WEST SUSSEX COUNTY COUNCIL CONSULTATION

TO:	Arun District Council FAO: Gerald Chibumu
FROM:	WSSC - Highways Authority
DATE:	8 September 2021
LOCATION:	57 River Road Littlehampton BN17 5DD
SUBJECT:	LU/251/21/PL Partial demolition of number 57 River Road, change of use & redevelopment to provide a flatted development comprising 6 No apartments, with private amenity space, parking & cycle storage. including the partial demolition of the adjacent boundary wall to provide a new pedestrian access & the creation of a floating pontoon with resident mooring spaces (resubmission following LU/247/21/PL).
DATE OF SITE VISIT:	n/a
RECOMMENDATION:	Advice
S106 CONTRIBUTION TOTAL:	n/a

TITLE: PROPOSED GROUND FLOOR PLAN

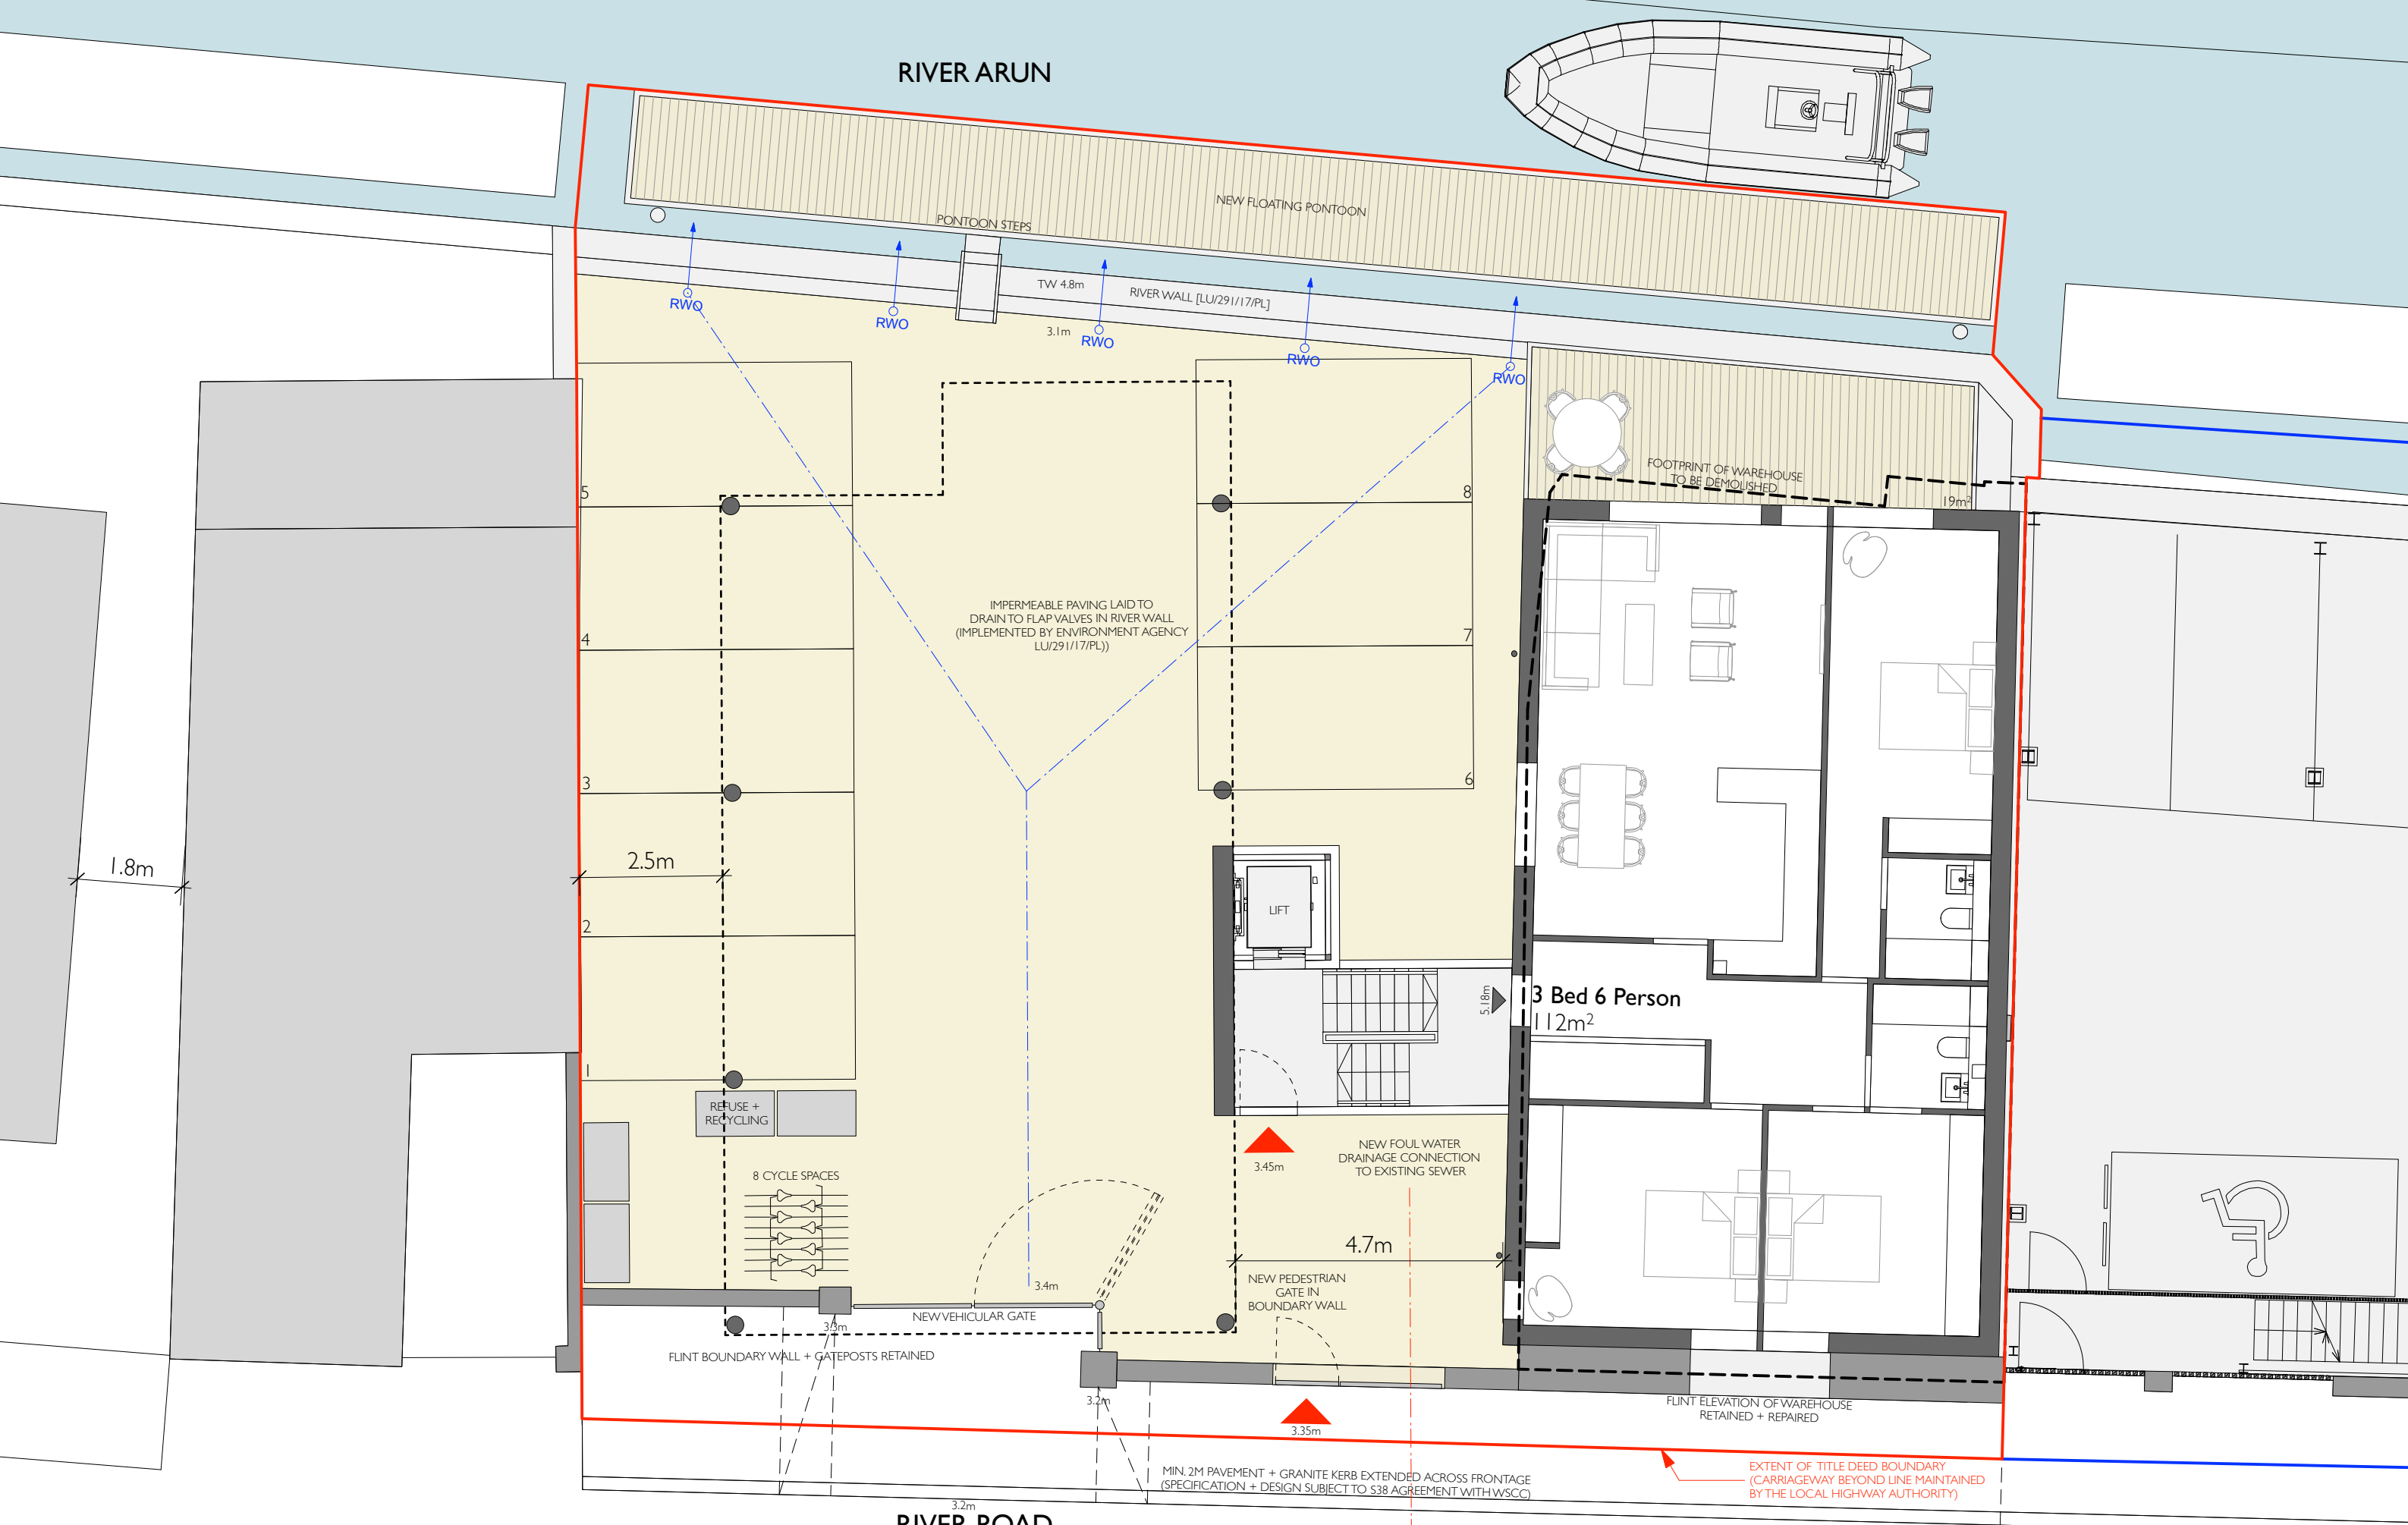
The applicant proposes a 2m minimum width footway across the entire frontage of the site, including a 4.5m wide dropped kerb for vehicular access. These works would be subject to Section 278 and 38 agreements - the applicant is advised to enter into early discussions with WSSC regarding the proposed works.

The proposed vehicular gates will open inwards of the site so as not to obstruct the highway. Ideally the gates would be positioned a minimum of 5m back from the back edge of the carriageway to allow a vehicles to wait clear of the highway whilst the gates are in operation. However given that the existing gates are currently located in the same position and that the proposed footway and dropped kerb will increase the distance of the gates from the back edge of the carriageway, the LHA would not raise any objections to the proposed gate positioning in this location.

The proposed parking area will provide parking for 8 vehicles. It is assumed that this provision will remain unallocated for the development. Based upon the proposed plans demonstrating 4 x 3-bed flats and 2 x 2-bed flats, the WSCC car parking demand calculator would expect that 10 parking spaces are required for a development of this size and location, to include visitor provision. The LHA anticipate that of shortfall of two parking spaces, one of these would likely be visitor provision, therefore, there is a potential shortfall in residents' parking of one space. The applicant is advised to consider whether a 9th parking space could be accommodated on site. The LPA may wish to consider the potential impacts of this development on on-street parking from an amenity point of view. Each parking space meets minimum specifications of 2. x 4.8m as set out in Manual for Streets, and there appears to be sufficient space for vehicles to turn on site and exit in a forward gear.

No part of the development shall be first occupied until such time as the vehicular access serving the development has been constructed in accordance with the details shown on the drawing titled Proposed Ground Floor Plan and numbered 1908 P 200 Rev 4.
